**Erection of three tourist accommodation units- Stockbridge House, High Street, Stockbridge, SO20 6EX**

This covering letter is prepared by Southern Planning Practice Ltd on behalf of Mr & Mrs Dunlop in support of an application for a minor material amendment involving the variation of condition 02 of planning permission 21/01171/FULLN for the *Erection of three tourist accommodation units* at the above property (PP ref **12712874**).

North West Elevation

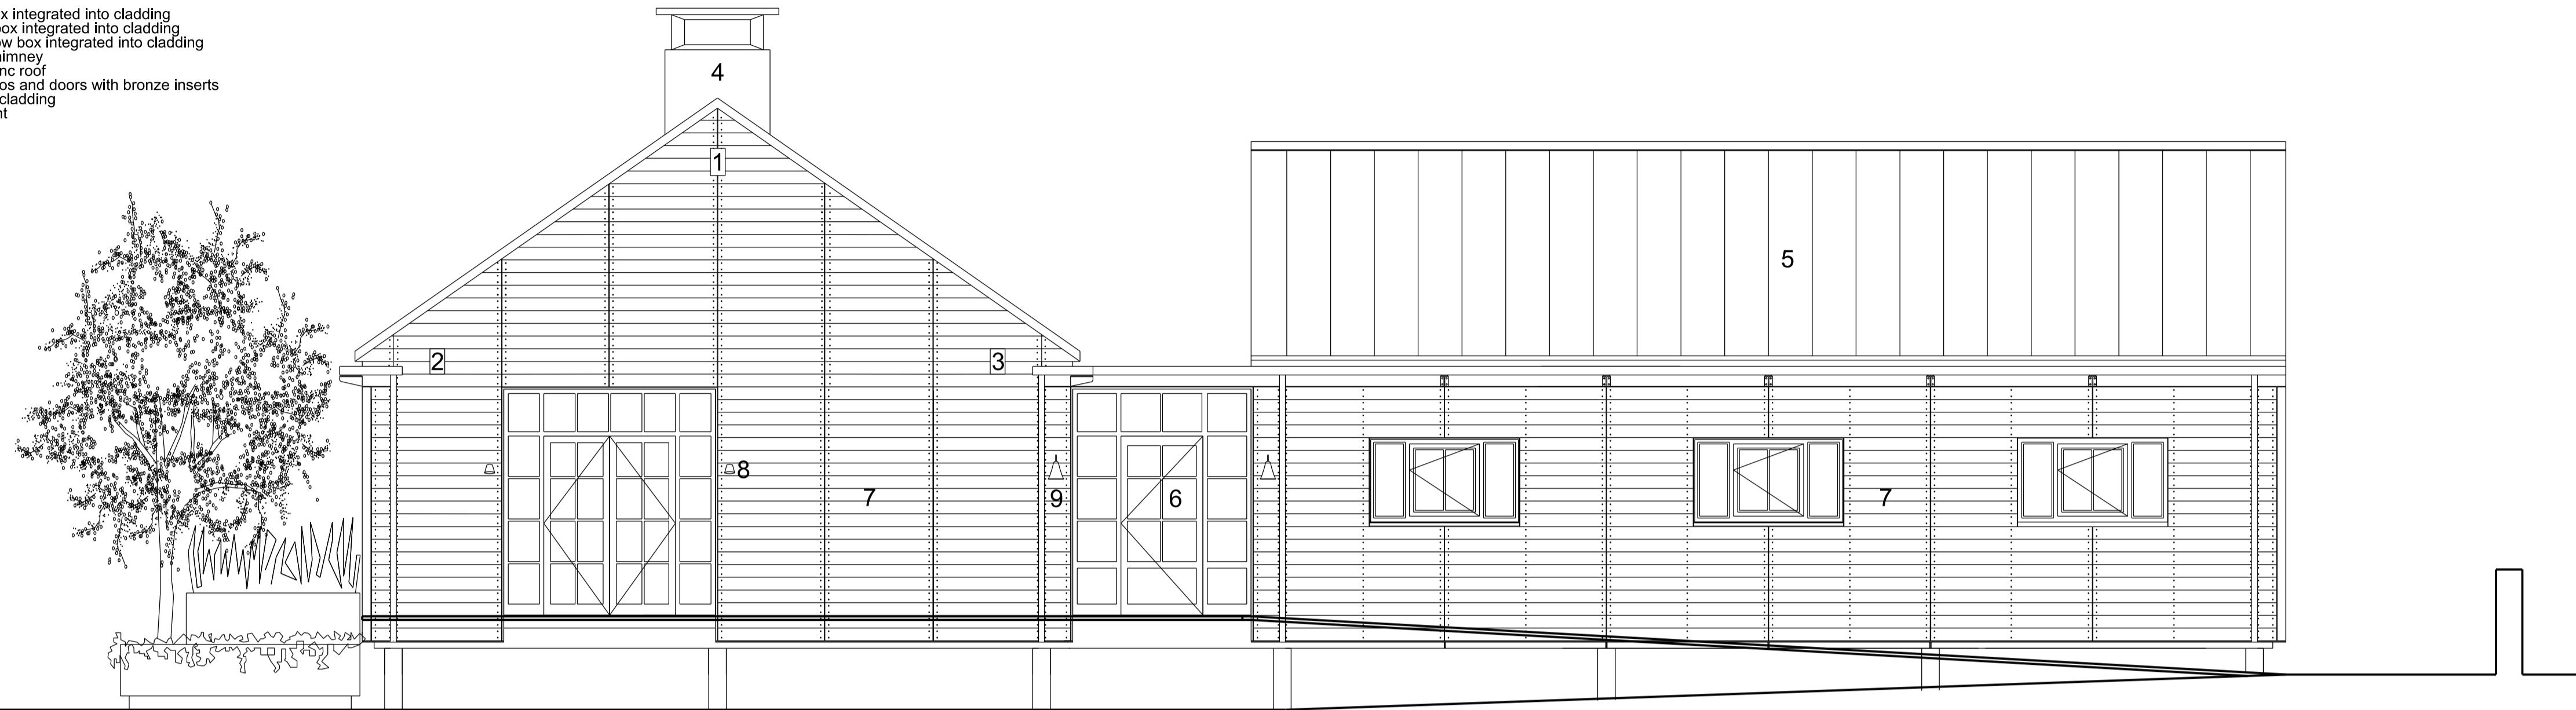
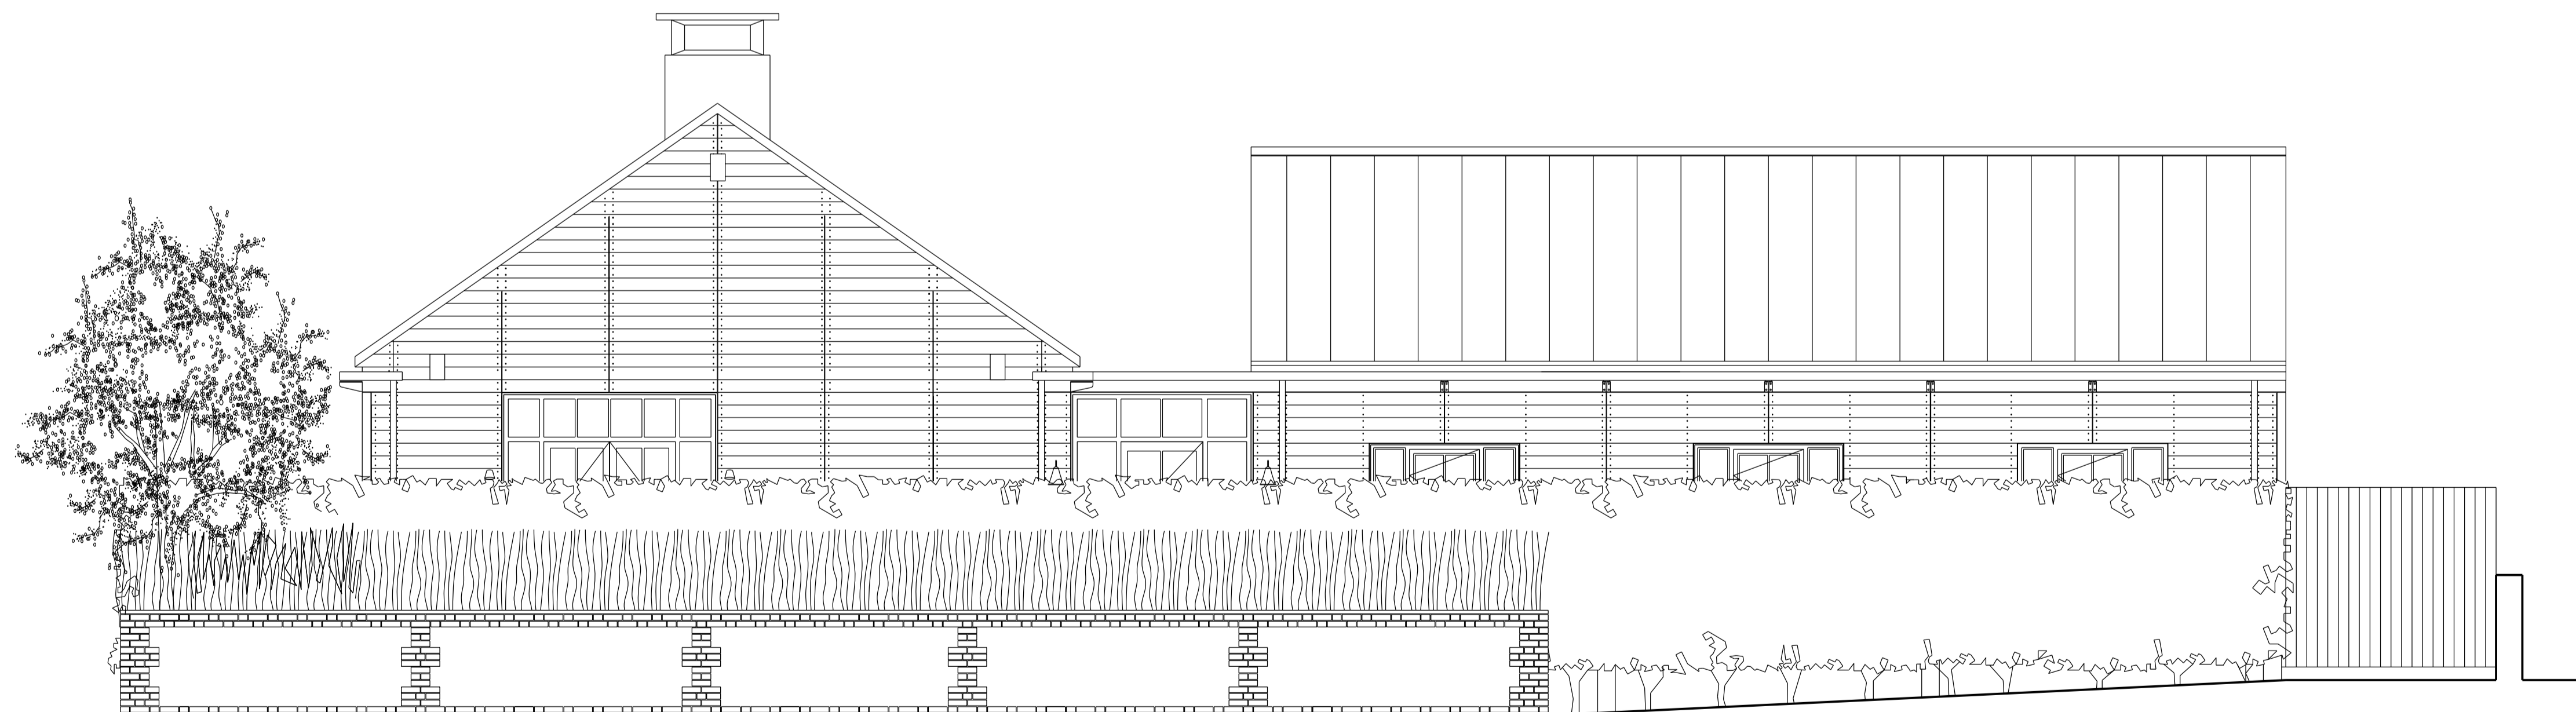
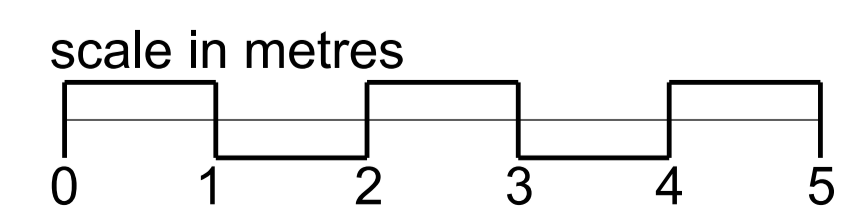
There would four additional windows inserted, and the approved window would include a doorway on the north west elevation. Three of the four additional windows would serve the hallway the and the larger additional window would serve the bedroom of unit 3. The additional doorway in the approved window would provide a secondary access into the main entrance hall. The proposed decking platform would serve the new doorway and form access

ramp to this doorway, running parallel with this elevation. These changes are as shown on plan **North West Elevation - 239(11)101A**.

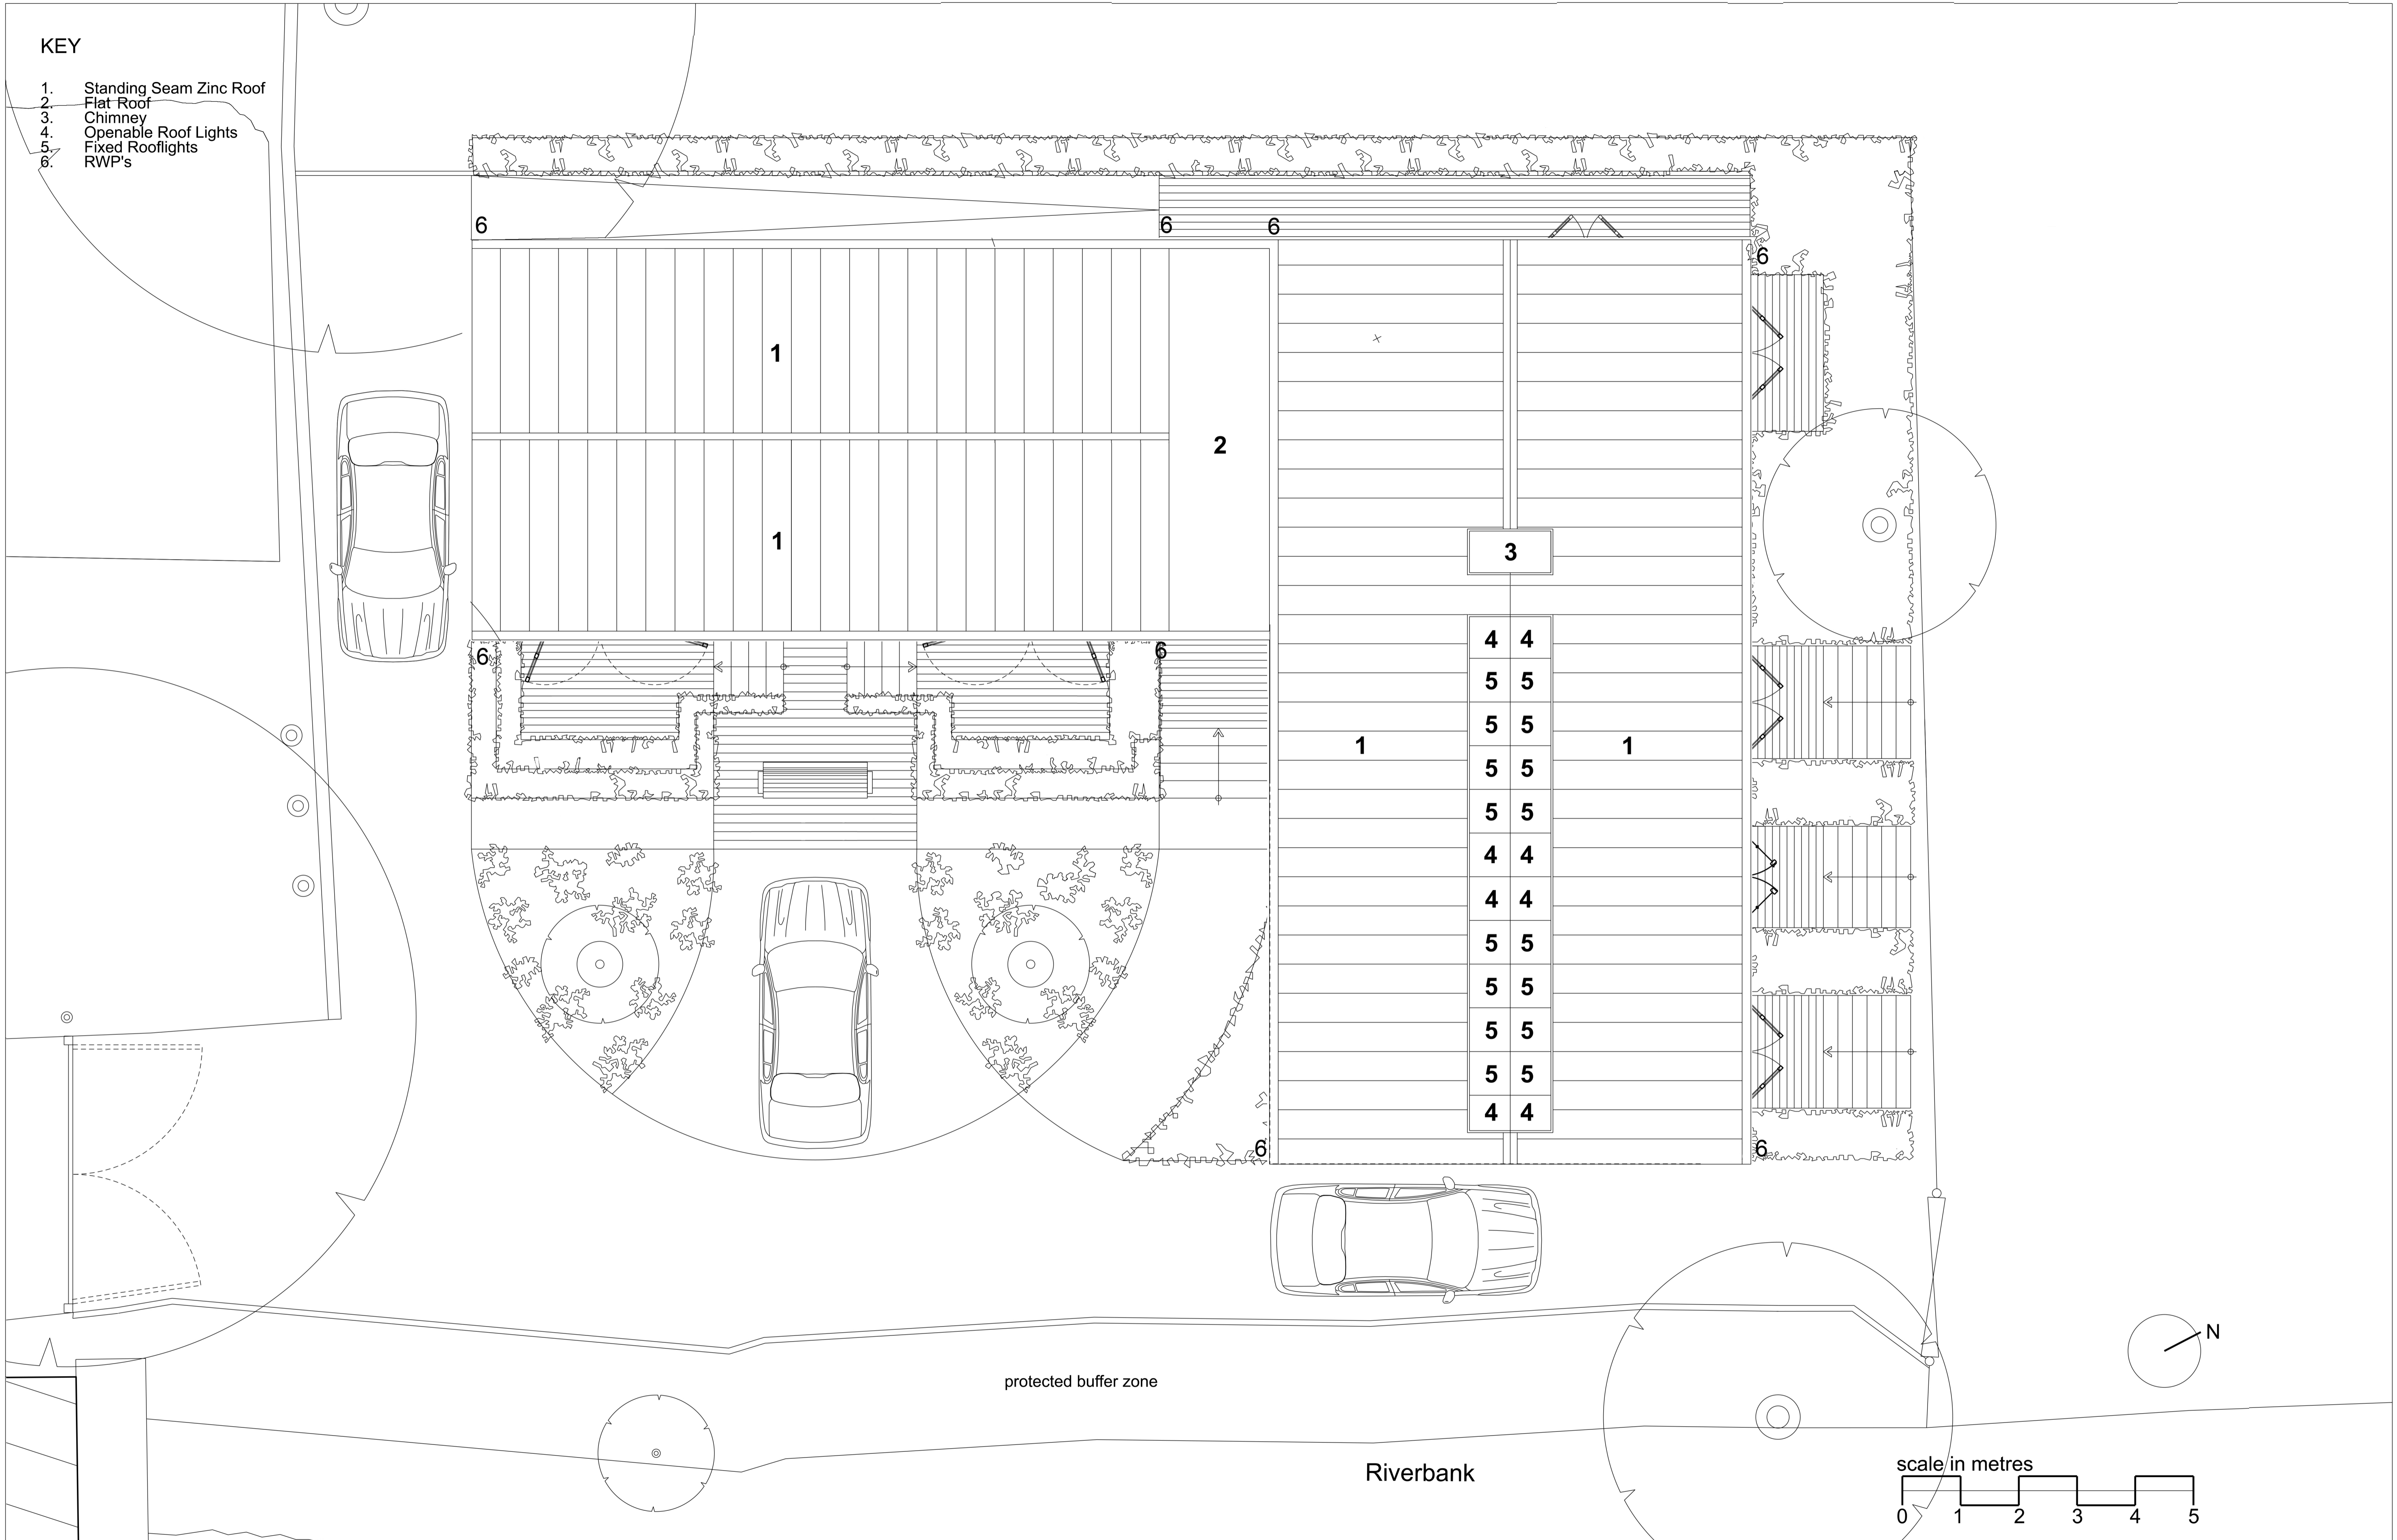
The revised layout is reflected in the revised roof plan and site plan (**Roof Plan 239(10)004 A** and **Site Plan 239 (10)00 2H**).
